MEMORANDUM

TO: Jean Fraser, Planner
FROM: David Senus, PE
DATE: June 10, 2015
RE: Bangor Savings Bank, Preliminary Level III Site Plan Application

- Preliminary Level III Site Plan Application and attachments, dated May 13, 2015, prepared by Gorrill Palmer, on behalf of Bangor Savings Bank.
- Engineering Plans, Sheets C002, C101, C102, & C401, dated May 13, 2015, prepared by Gorrill Palmer, on behalf of Bangor Savings Bank.
- Boundary & Topographic Survey, dated March 24, 2015, prepared by Owen Haskell, Inc., on behalf of Gorrill Palmer.

Drawing No.
C002

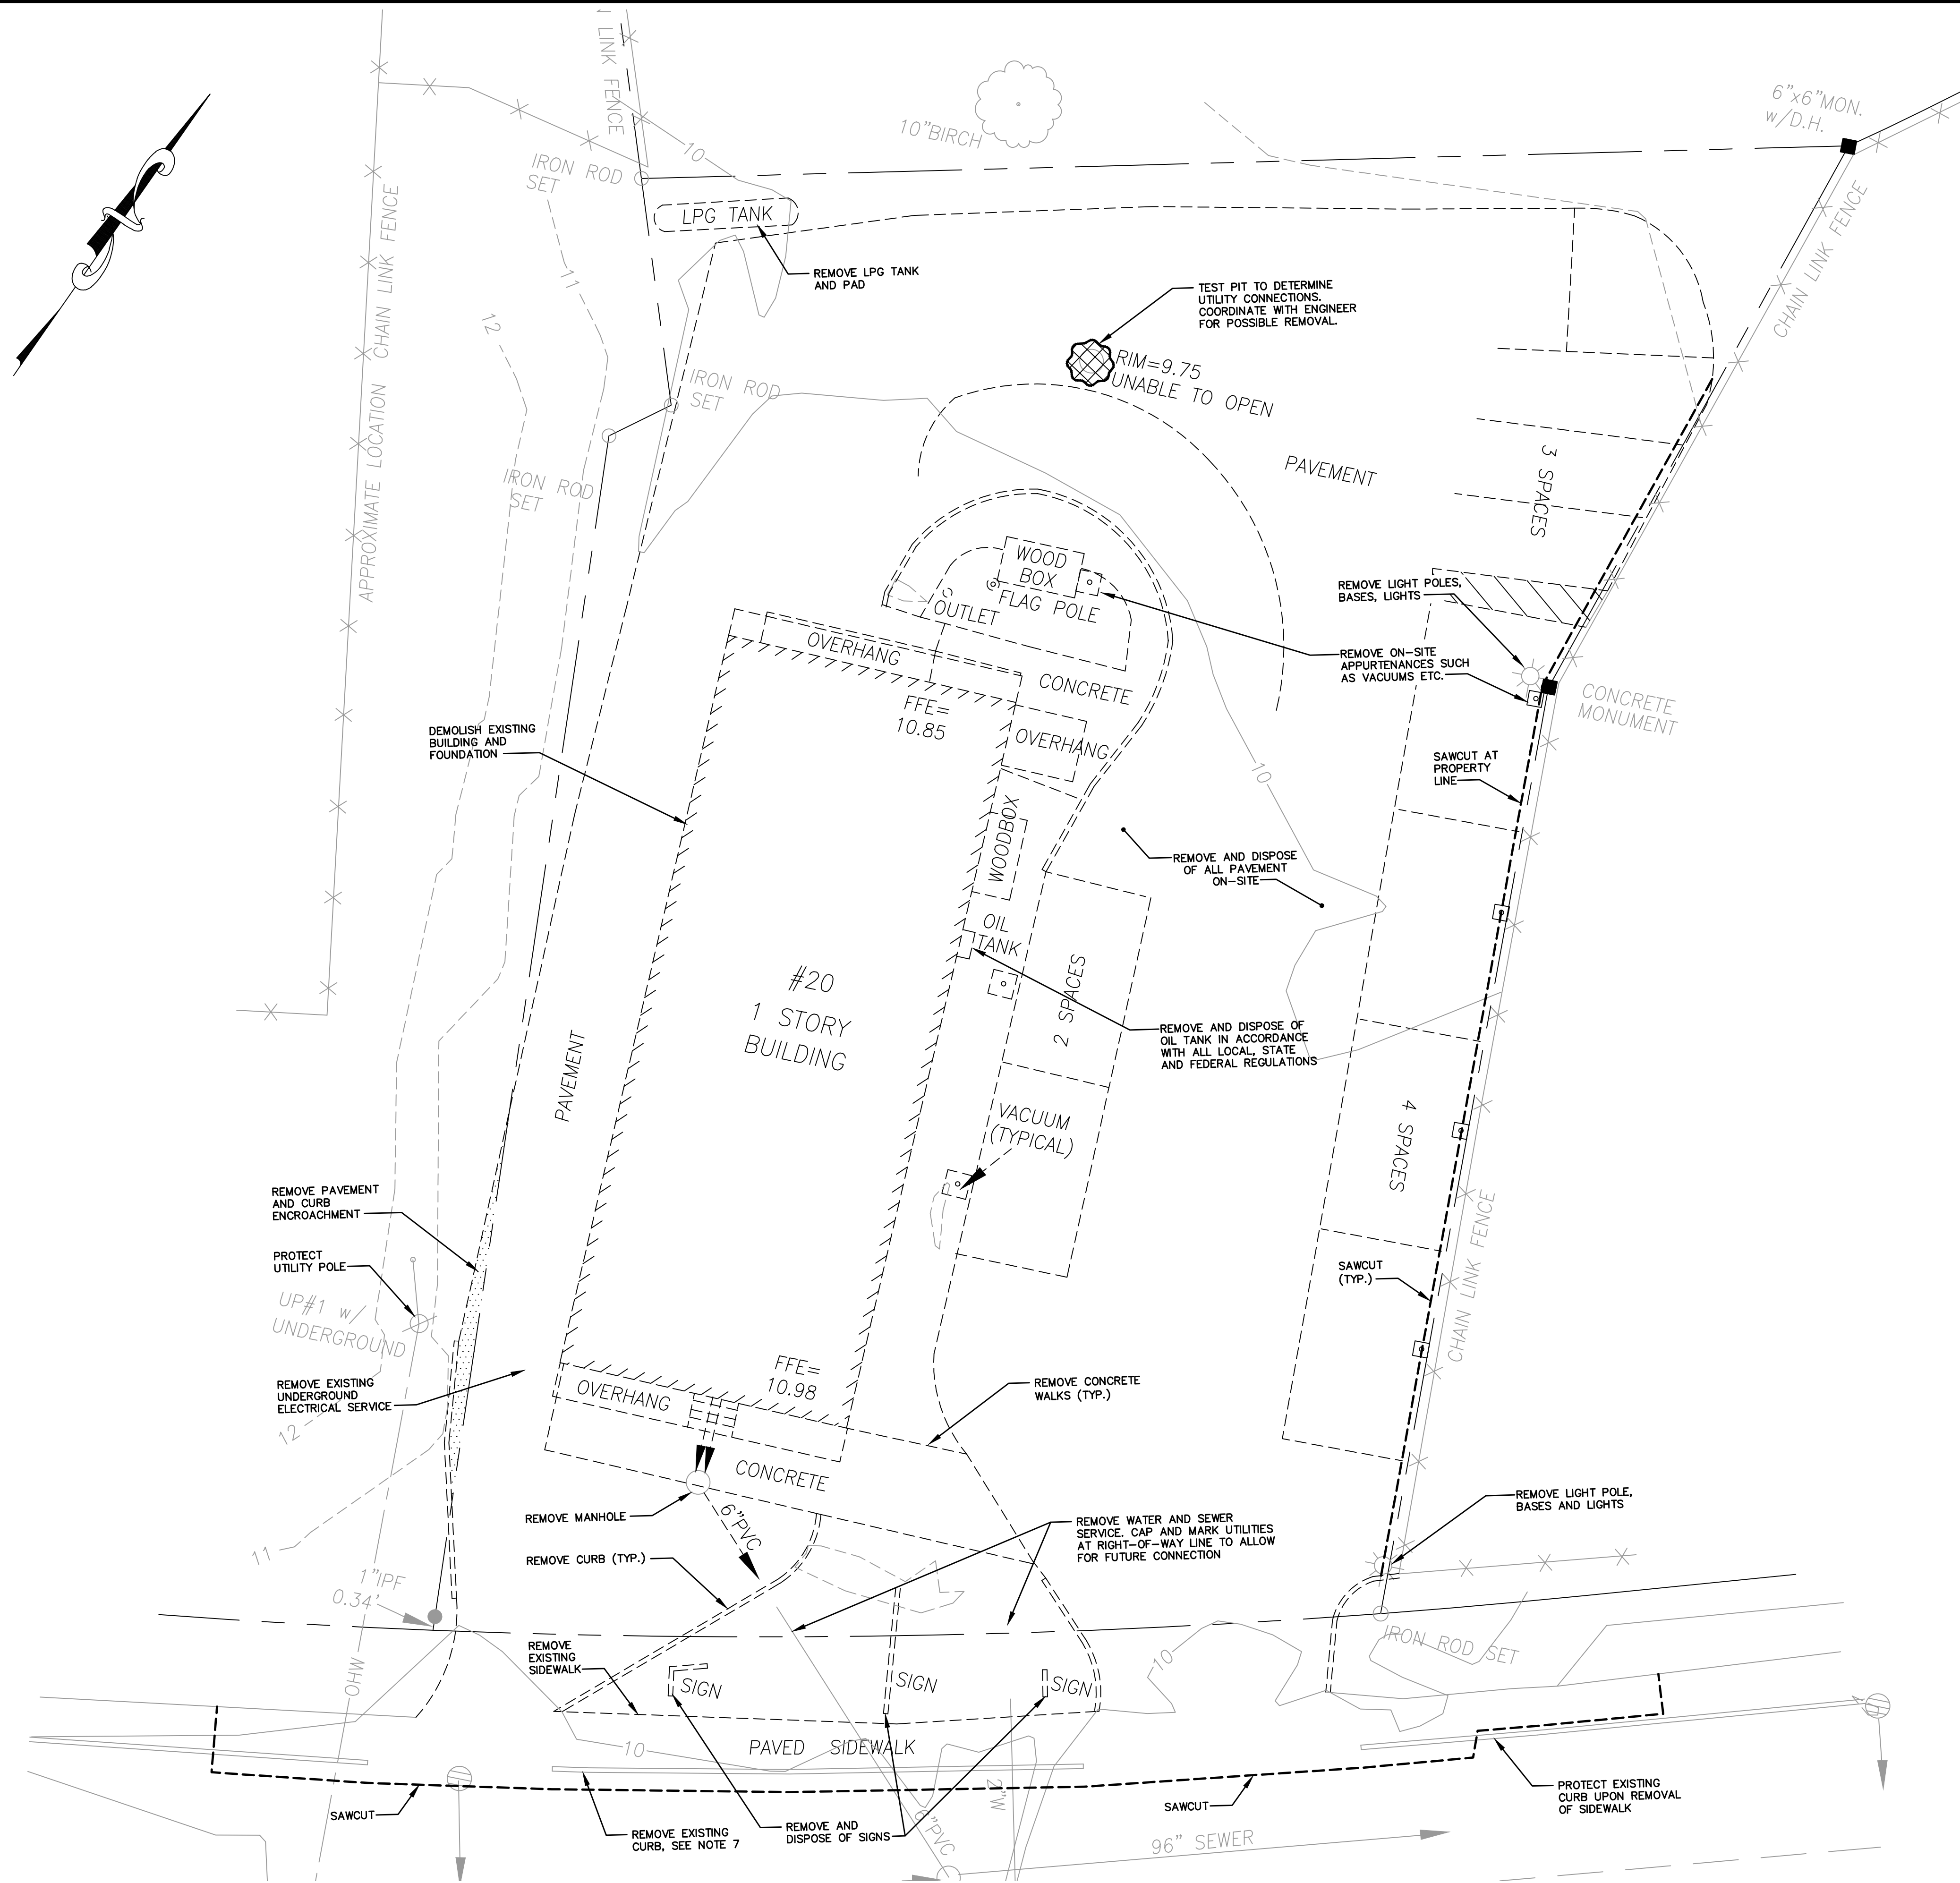
- 2) Note 5 on Sheet C002 states that the General Contractor shall submit a Construction Management Plan to the City of Portland prior to demolition; the Applicant should note that a Construction Management Plan is required to be submitted as part of the Final Site Plan Application, per the General Written Submissions Checklist. If requested by the Applicant, Planning Staff and the Planning Board may allow for the construction management plan to be submitted for review and approval prior to the issuance of a building permit (as a condition of the Site Plan approval).
